CITY OF ALBUQUERQUE

May 21, 2018

**Re: Utility Trailer Sales
Erosion and Sediment Control Plan
Engineer's Stamp Date 5-7-18 (K09E026B)**

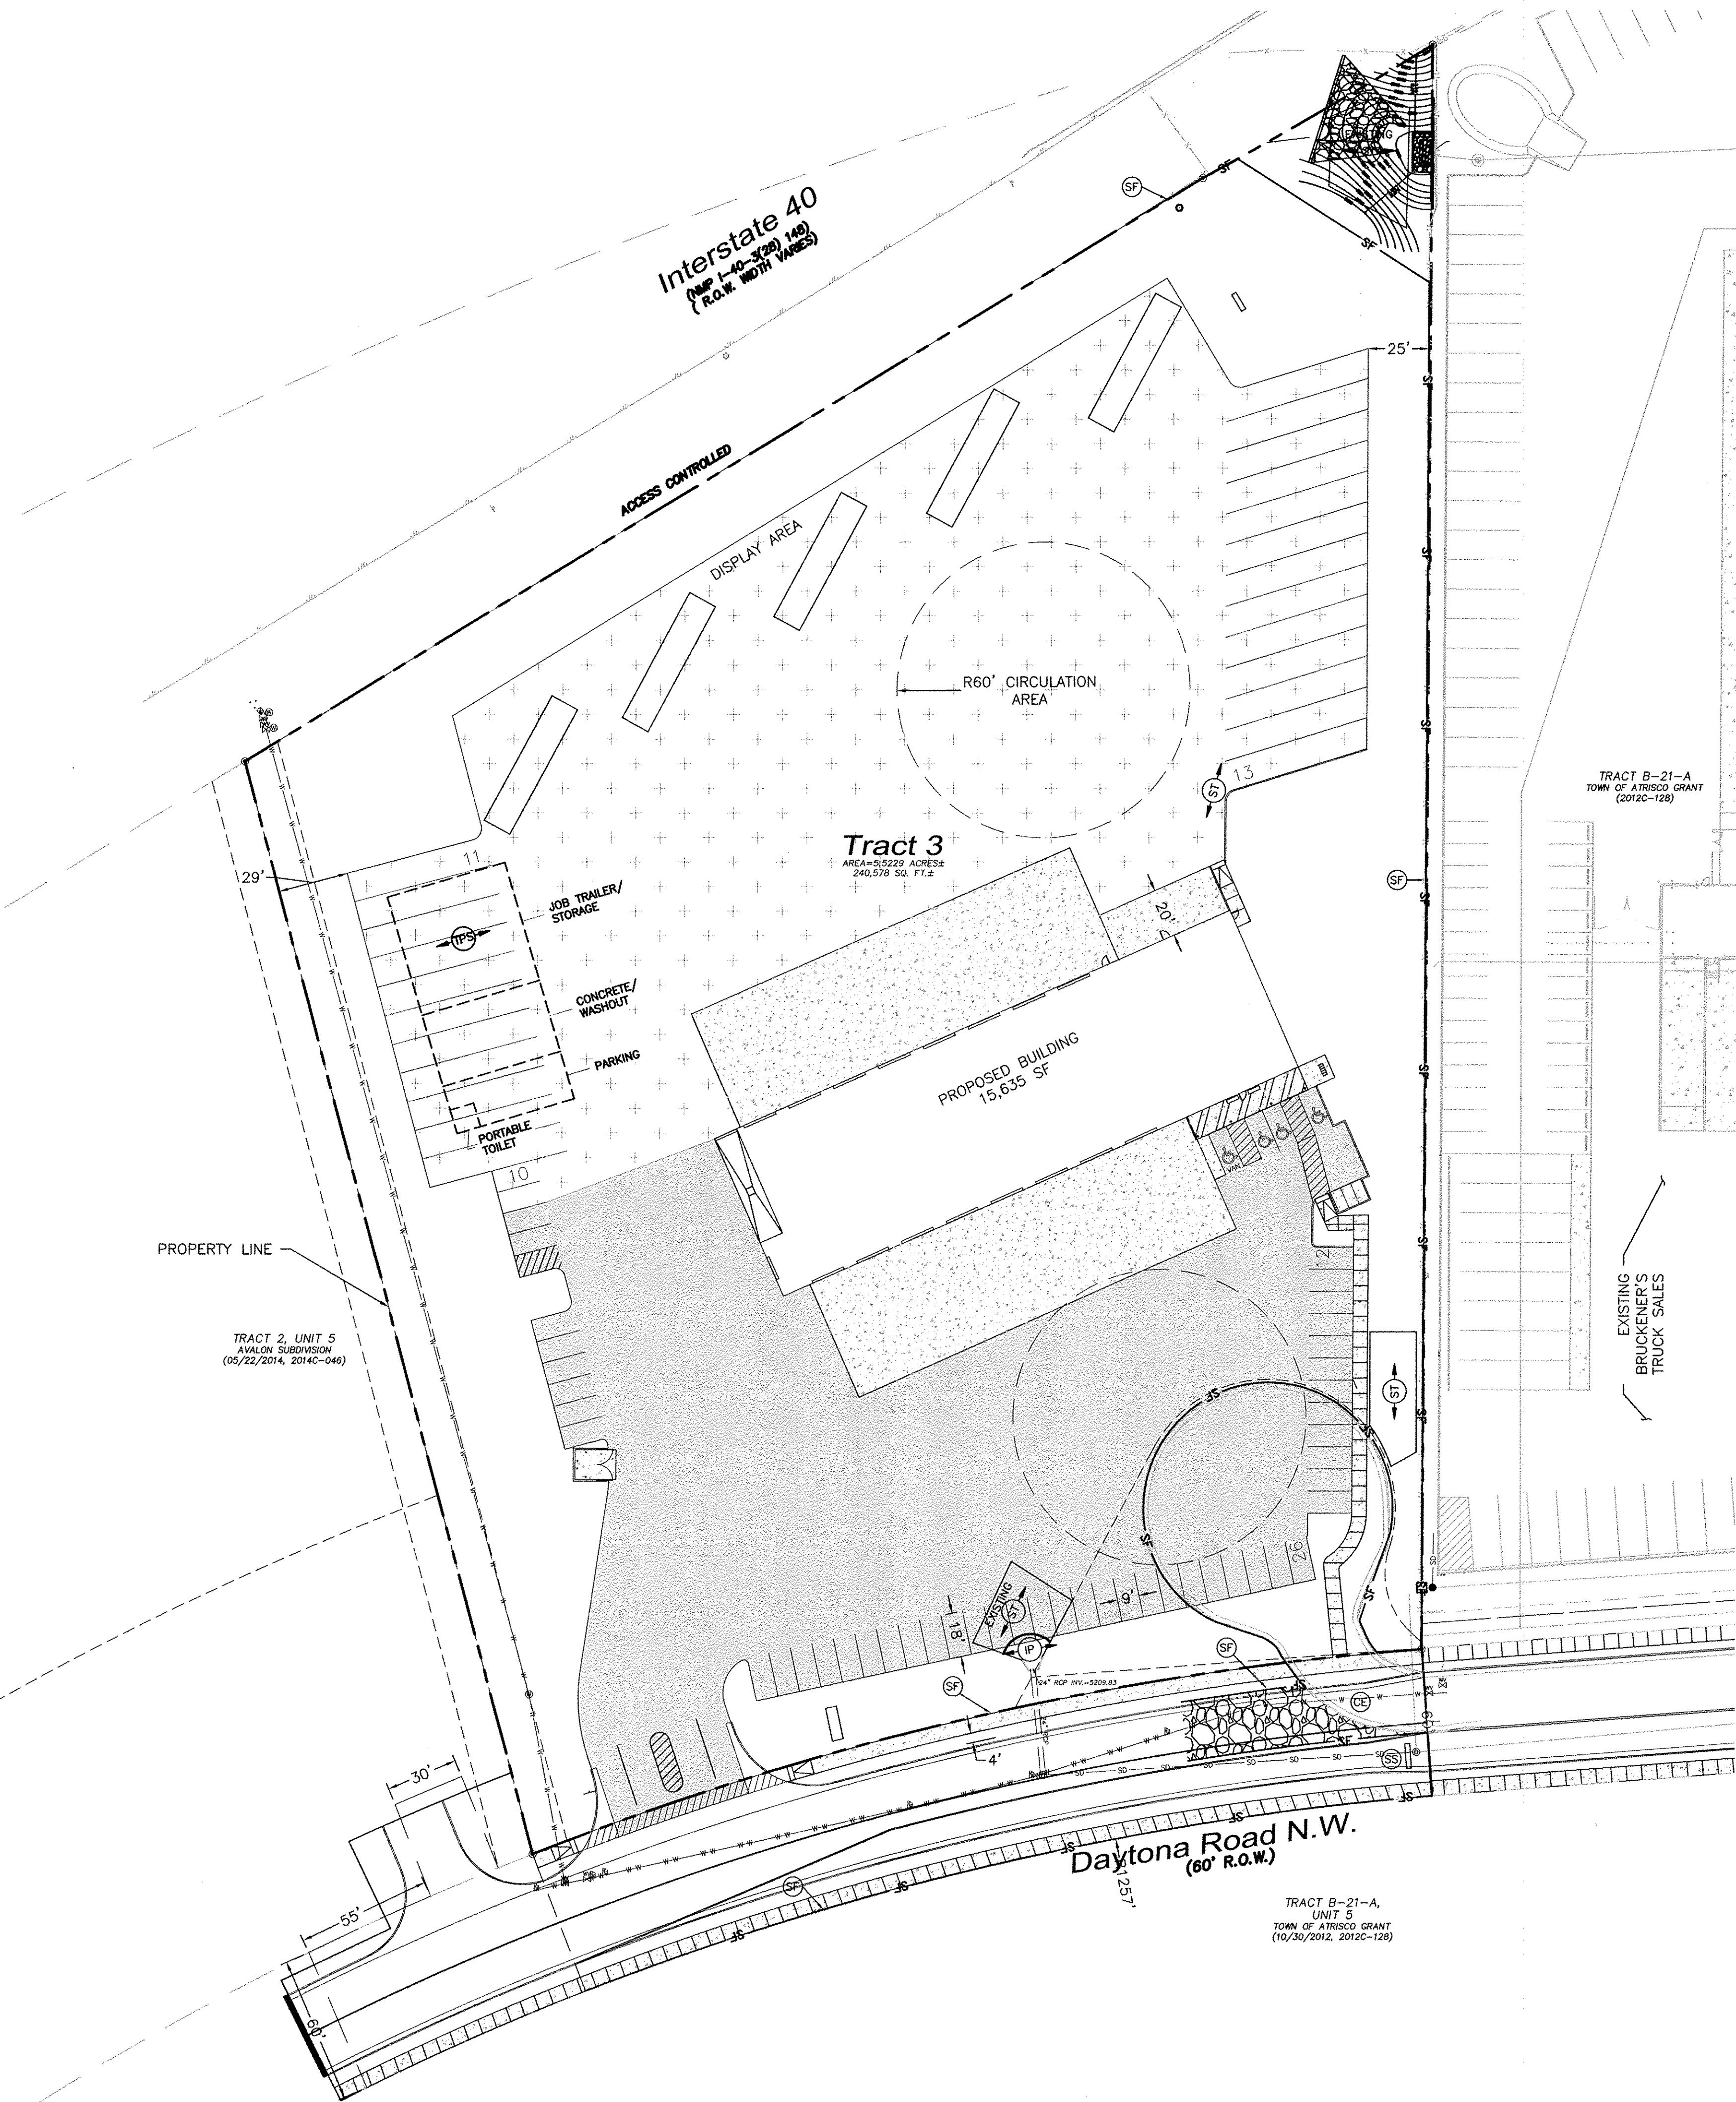
1. Provide existing and proposed grades and proposed inlets/pipes.
2. The plan appears to show silt fence across a paved road. Silt fence doesn't work on impervious surfaces unless a mulch sock or similar is placed at the bottom.

3. The information sheet did not include Work Order approval, therefore the disturbance would be limited to the southern property line and the silt fence on the southern side of the ROW is unnecessary.

- a. If Work Order approval is requested, please let me know and in that case, propose inlet protection for the inlet(s) in the street east of the site and remove the sidewalk shown on the south side of the street as there is no sidewalk east of this site to tie-into.

4. What is proposed for the existing day-lighted storm drain on the site? The pipe opening should have a BMP prior to grading of the site.
5. Provide limits of the silt fence along the northern edge of the project.

6. I forget if the major source of run-on in the earthen arroyo has been cut-off by the I-40 channel, but you may still get some flow in the channel from an earthen basin(s) south of I-40 and from I-40 (inlet(s) in median?). How will this be addressed?
